Planning Report
Limerick City & County Council

ABP Ref: ABP-310286-21
Location: Thomastown and Fantstown, Kilmallock, Co. Limerick
Dev. Description: Proposed Railway Order - Replacement of 7No. manned level crossing on the main Dublin to Cork Railway Line

This planning report relates to the Fantstown and Thomastown level crossings, which are located within County Limerick. We understand that Cork County Council have provided comments in respect of the five other level crossings that are the subject of this Railway Order application, located within County Cork. The report is set out under the relevant issues requested by the Board.

Figure 2.5: XC201 Thomastown Proposed Route Alignment

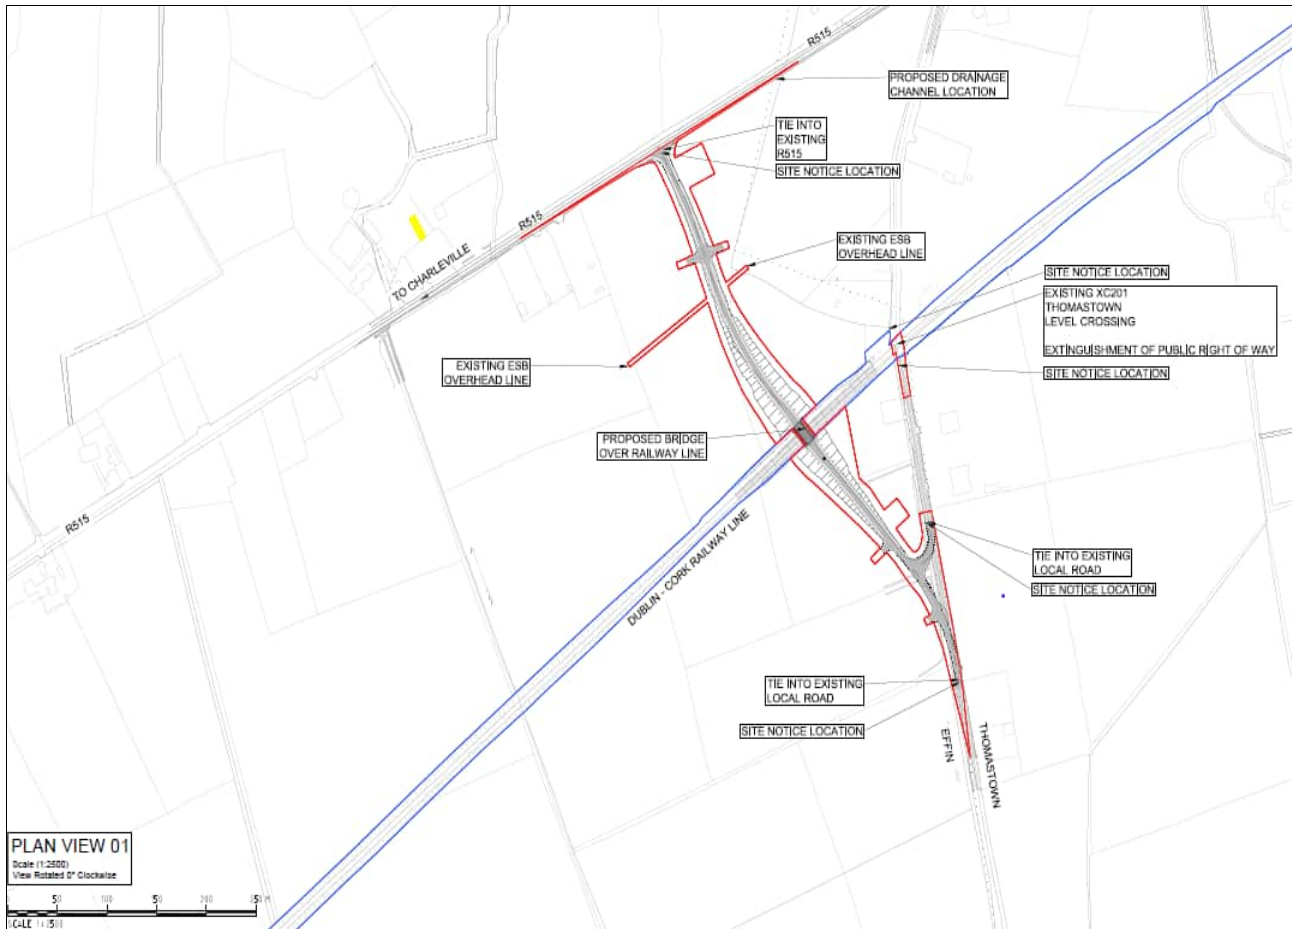
- Limerick City and County council should be kept apprised of the scheme progression with quarterly updates from Irish Rail.
- To avoid any unnecessary queuing of traffic on the R515 at the proposed junction, the realigned road from its junction with the R515 should be widened locally to allow traffic from the R515 enter onto the proposed road and pass safely any traffic (including large vehicles such as agricultural machinery) that may be queuing in the opposite direction. The length of the road that will require localised widening to be agreed with Limerick City and County Council prior to the commencement of construction.
- Design Phase

(a) To avoid any unnecessary queuing of traffic on the R515 at the proposed junction, the realigned road from its junction with the R515 should be widened locally to allow traffic from the R515 enter onto the proposed road and pass safely any traffic (including large vehicles such as agricultural machinery) that may be queuing in the opposite direction. The length of the road that will require localised widening to be agreed with Limerick City and County Council prior to the commencement of construction.
